**Consultation Response from KC,
Conservation and Design**
2021/90060 adj, 9, Station Road, Marsden, Huddersfield, HD7 6BS
Erection of take-away food outlet (within a Conservation Area)
Date Responded: 26.02.21 Responding Officer: NG Responding Ref: CA05
Context.

Project		
Proposed commercial unit.		
Address		
Former Swan Public House 5 and 7 Station Road Marsden HD7 6BS.		
Title		
Layout plans.		
Paper size	Drawing number	Date
A1	SW 02.	Nov 2020.

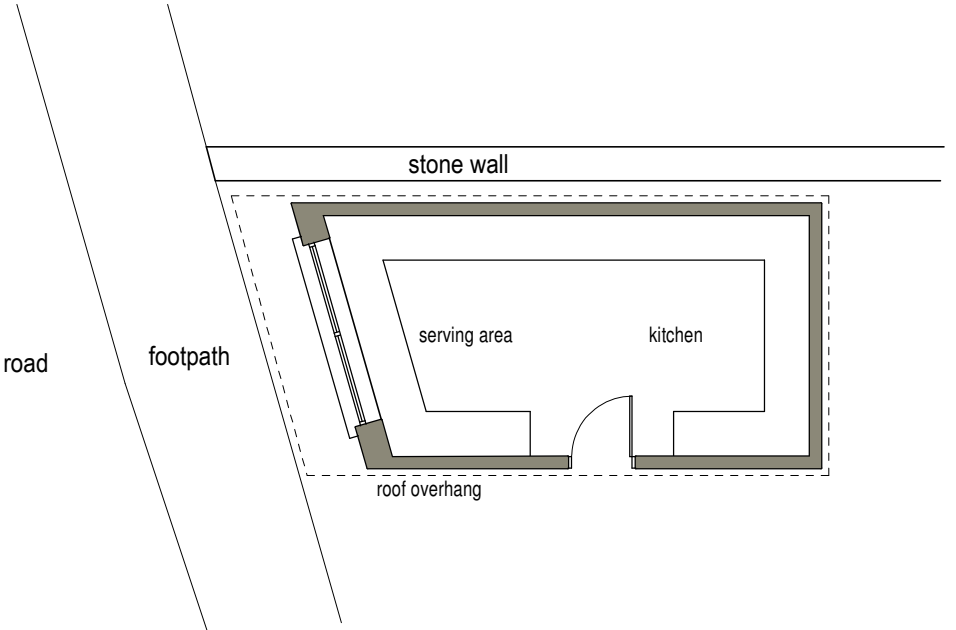
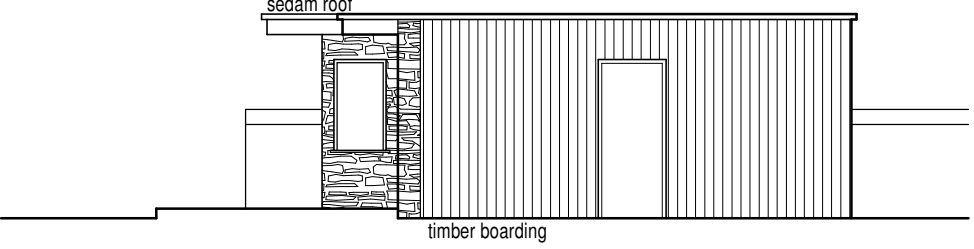
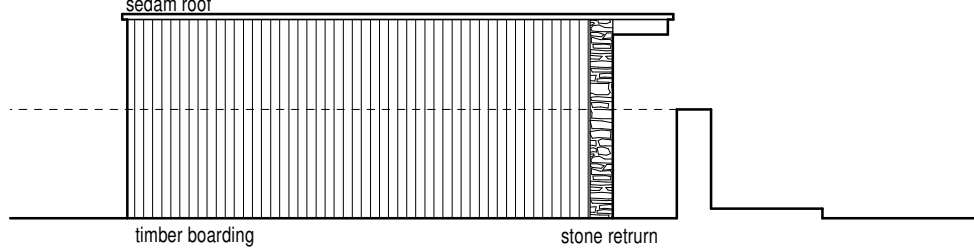
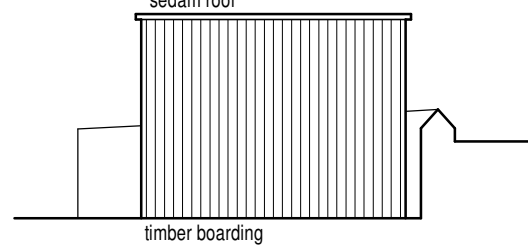
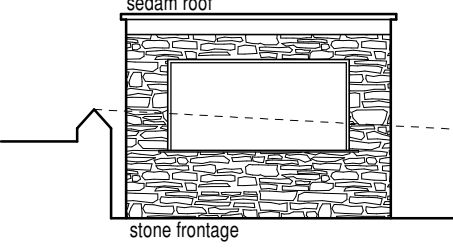
The scale and design form of the building is approximately that of a large garage. It would be located in a prominent location on the street corner presenting a jarring visual contrast to the streetscape which would adversely impact on the stone terrace and riverside location. The proposed building would also obscure streetscape views of the stone gable of the adjacent terraced property and thus have a disproportionately intrusive and adverse visual impact on the character of the building group and wider townscape.

Proposed site plan (1:100)

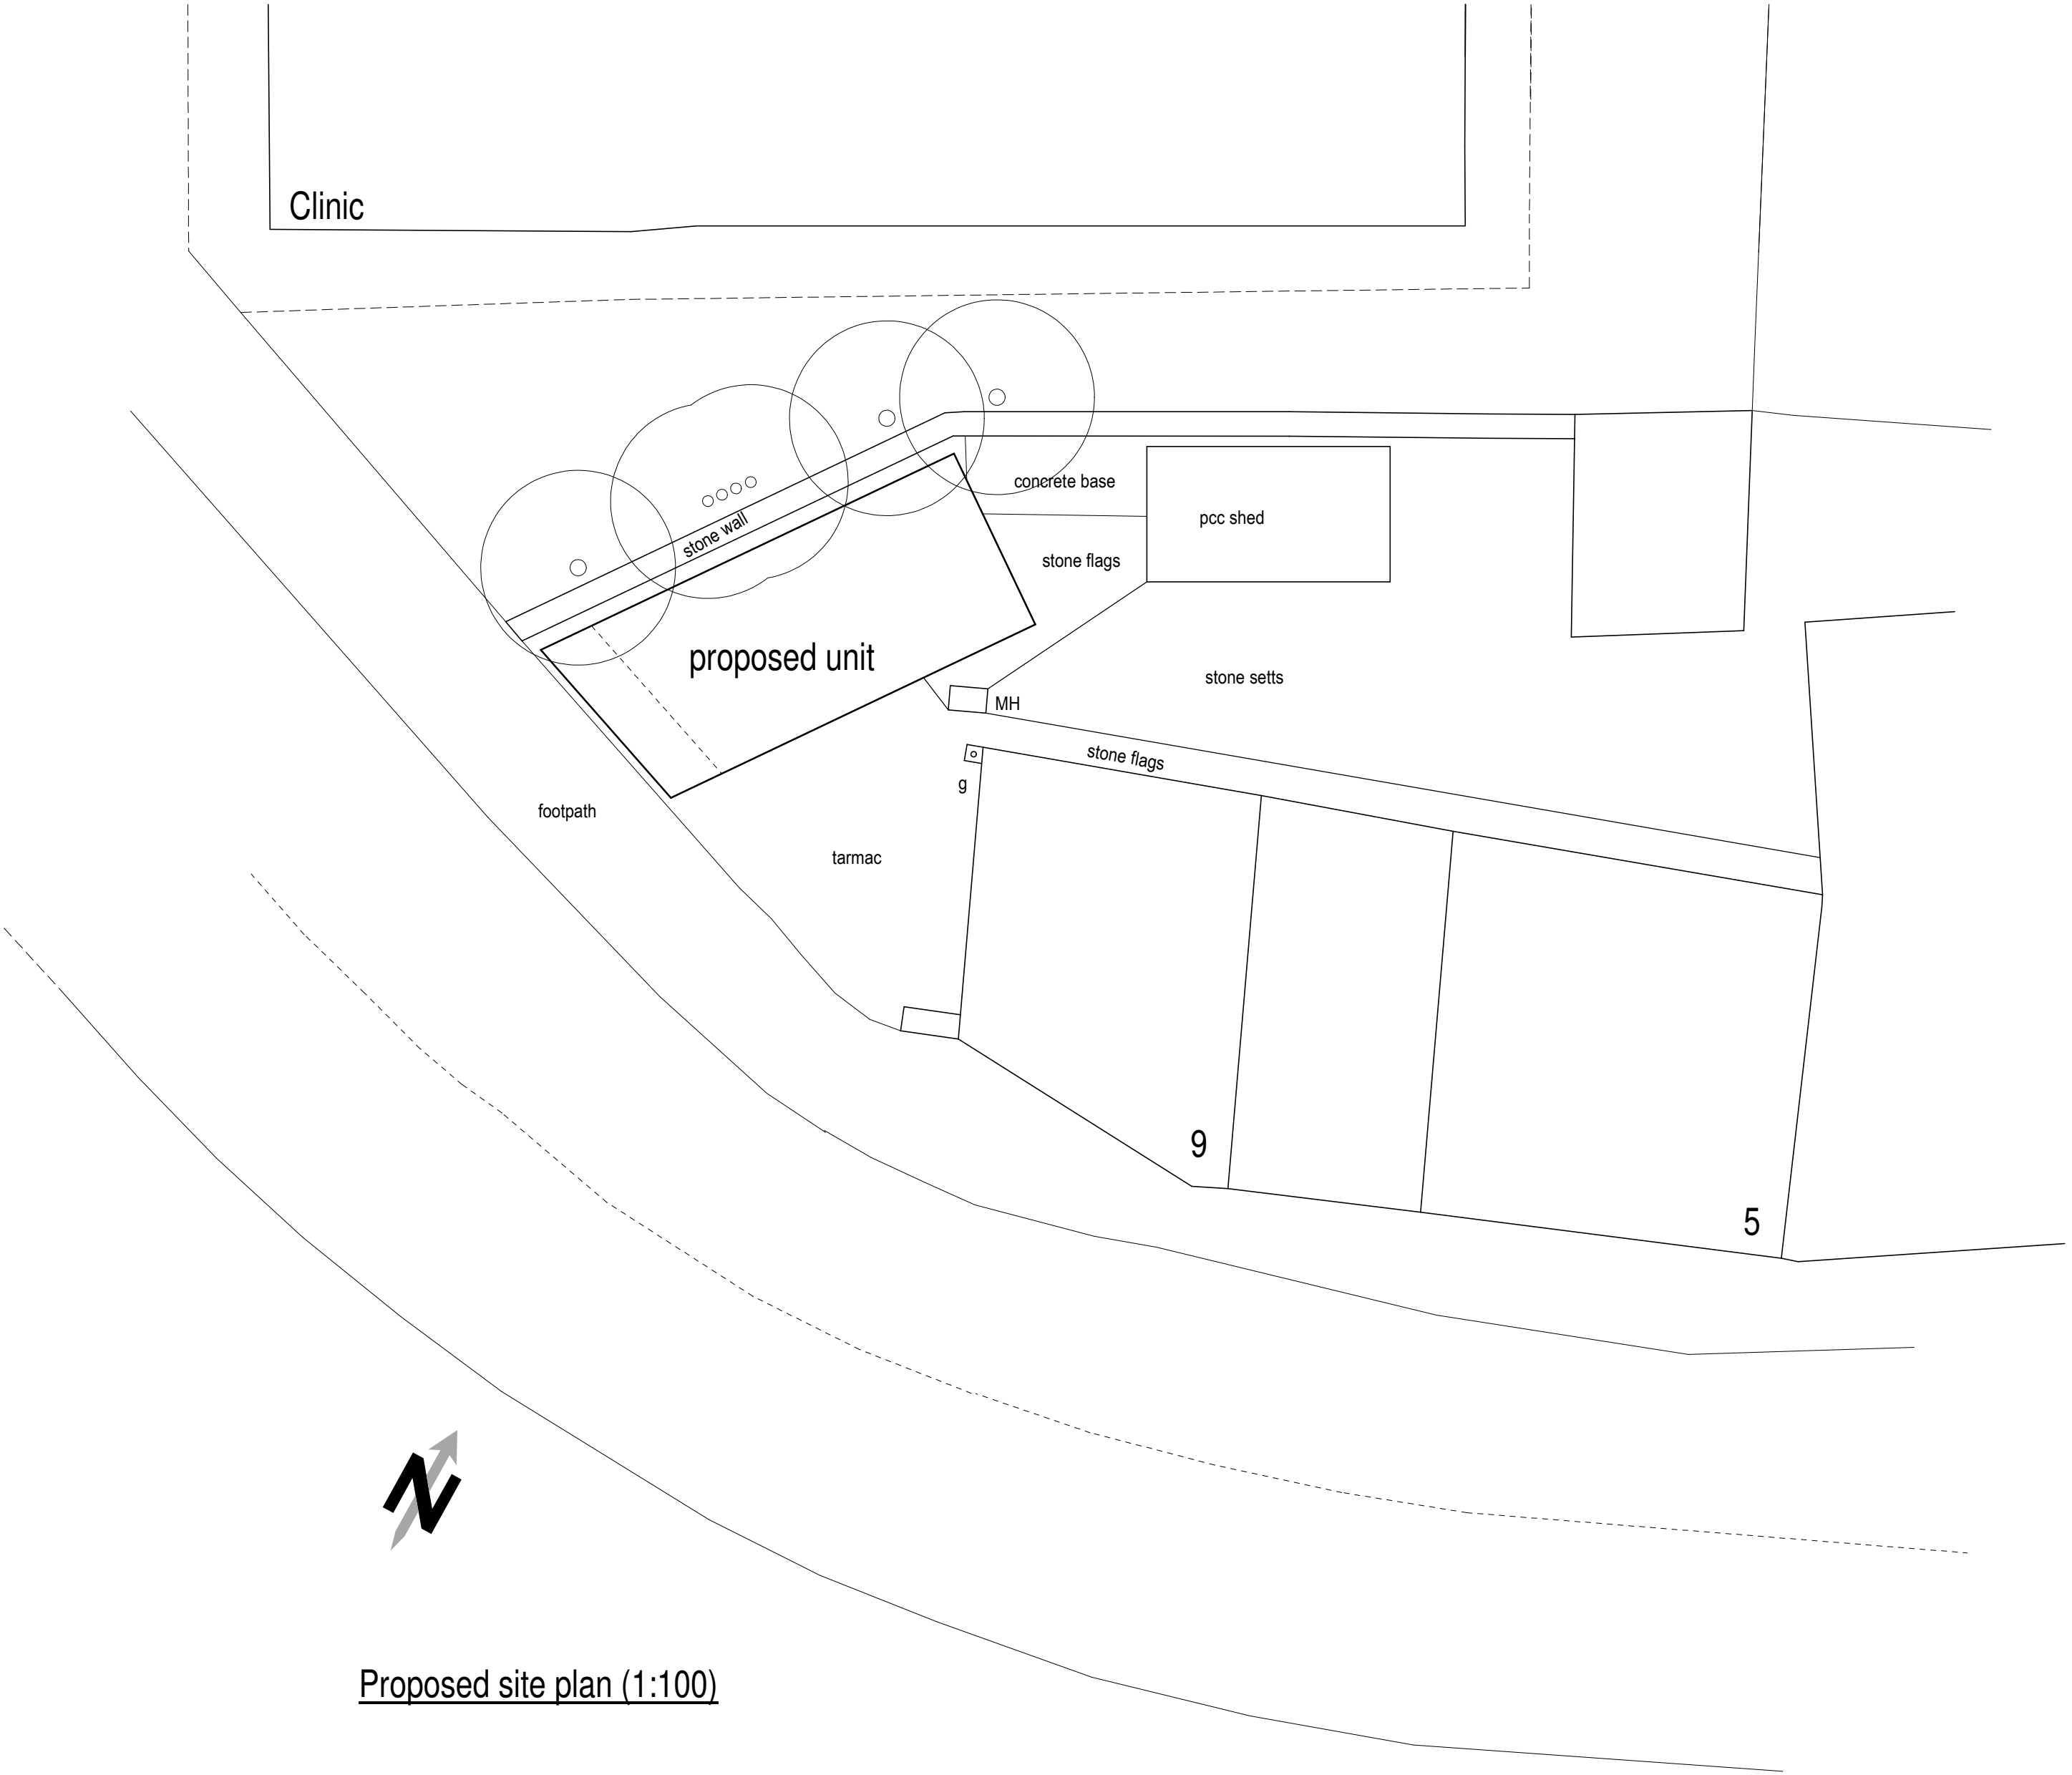
The proposed building would be located in the former garden/service yard of the adjacent terrace and is a flat roof, partially stone-faced cabin. The proposal does not include any details of how the unit would be serviced, including its ventilation, storage and disposal of refuse, or the means of lighting, signage, times of operation or even how the adjacent commercial units would be managed/serviced following the loss of the yard-space.

Furthermore, the erection of this building would have an adverse impact on the operational use of the adjacent former public house which has been adapted for alternative commercial uses, compromising the potential to access the service areas of the building group and limiting access to the communal refuse storage area. The proposed use would also conflict with the need to focus viable commercial
